**From:** [Harmon Rita T.](#)  
**To:** ["John Jacquez"](#)  
**Subject:** RE: Collete Park  
**Date:** Friday, October 23, 2015 10:32:31 AM

There needs to be some changes within the right of way on this project Collette Park Elementary, 2100 Morris, (H21/D010). I am putting together a sketch showing the changes tomorrow, and I was wondering if we could meet to discuss the changes with you and get your consent before construction moves forward. Could you check your schedule and let us know so we can meet on this. As always Rita, the contractor is on hold until we get this resolved, so the sooner the better.

# COLLET PARK ELEMENTARY ADDITIONS & RENOVATIONS ALBUQUERQUE PUBLIC SCHOOLS

GRADING AND DRAINAGE PLAN  
project no. 08-007

C-501

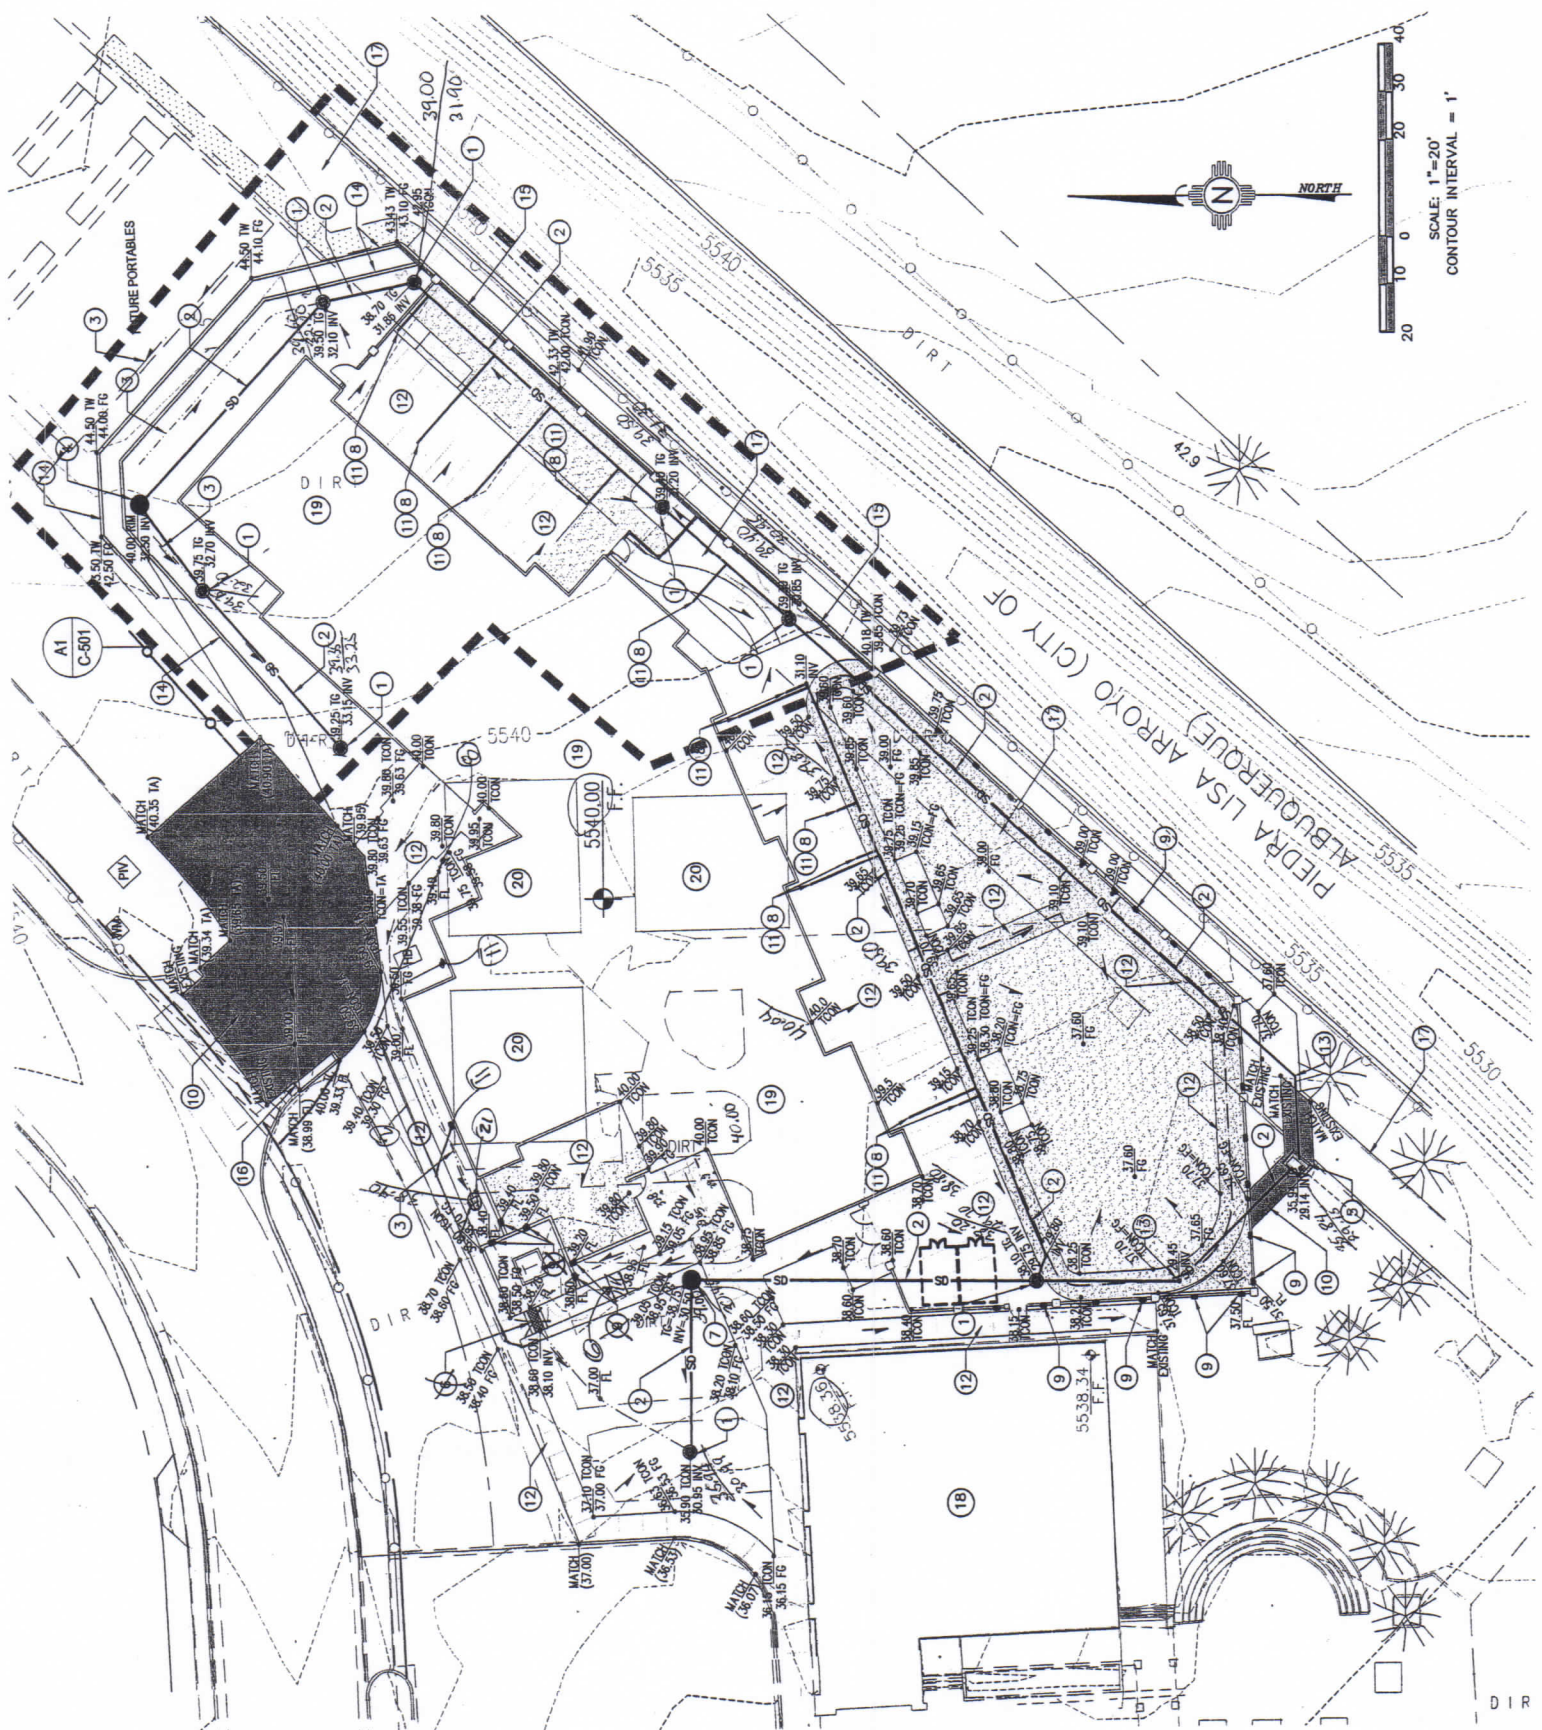
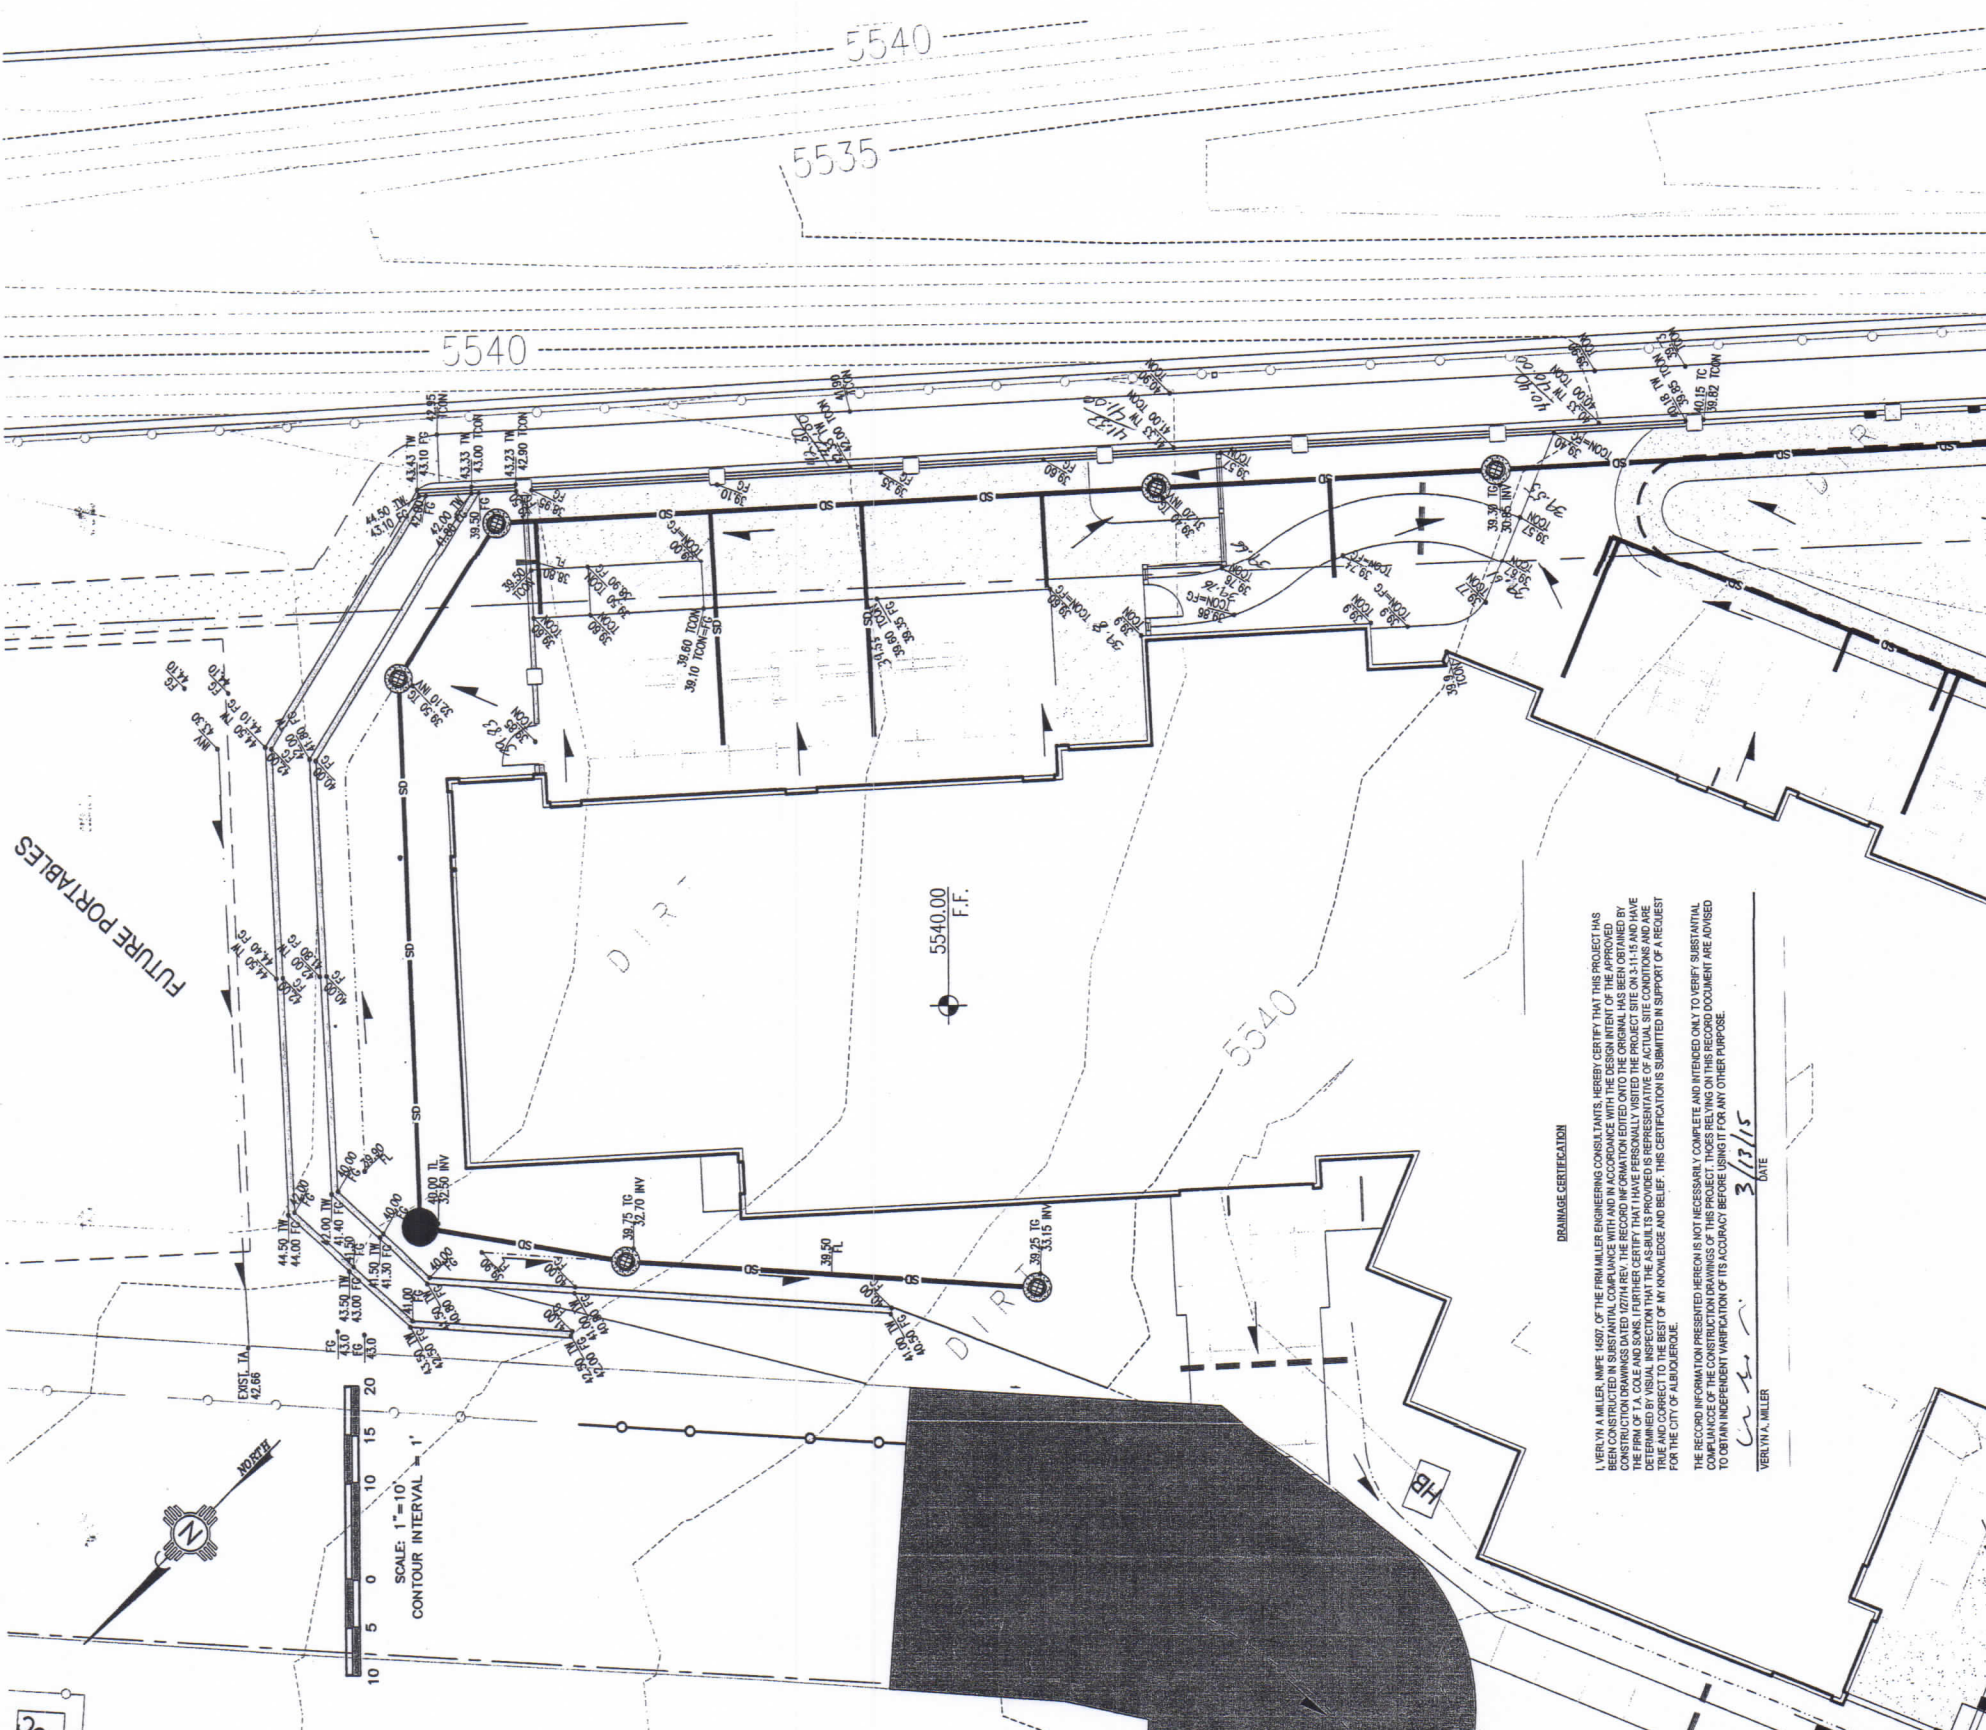
2.5:1 is the best I could do without having a wall over 12" tall. Remember that there is an existing wall that runs behind the sidewalk parallel to the sidewalk. These improvements are all behind the existing wall. The existing wall is about 18" to 24" tall. Look on google earth.

John,  
I can't scale the electronic. What is the slope here?

Please find the attached original grading and drainage plan and the revision (rfi 56). Due to existing utilities on site the invert of the sd pipe had to drop from 28 to 25.96. The previous design had a retaining wall, with the change in elevation we are now proposing a concrete slope blanket and the pipe mitered to the slope instead of the retaining wall.

John, Verlyn.  
I am ok with the revisions. When you submit the Engineer's Certification plan, submit the Approved plans as well as this revised plan. Put a bubble around the area in the plan view that has changed and show all the as-built information on the revised plan. I will include this correspondence in the drainage file.
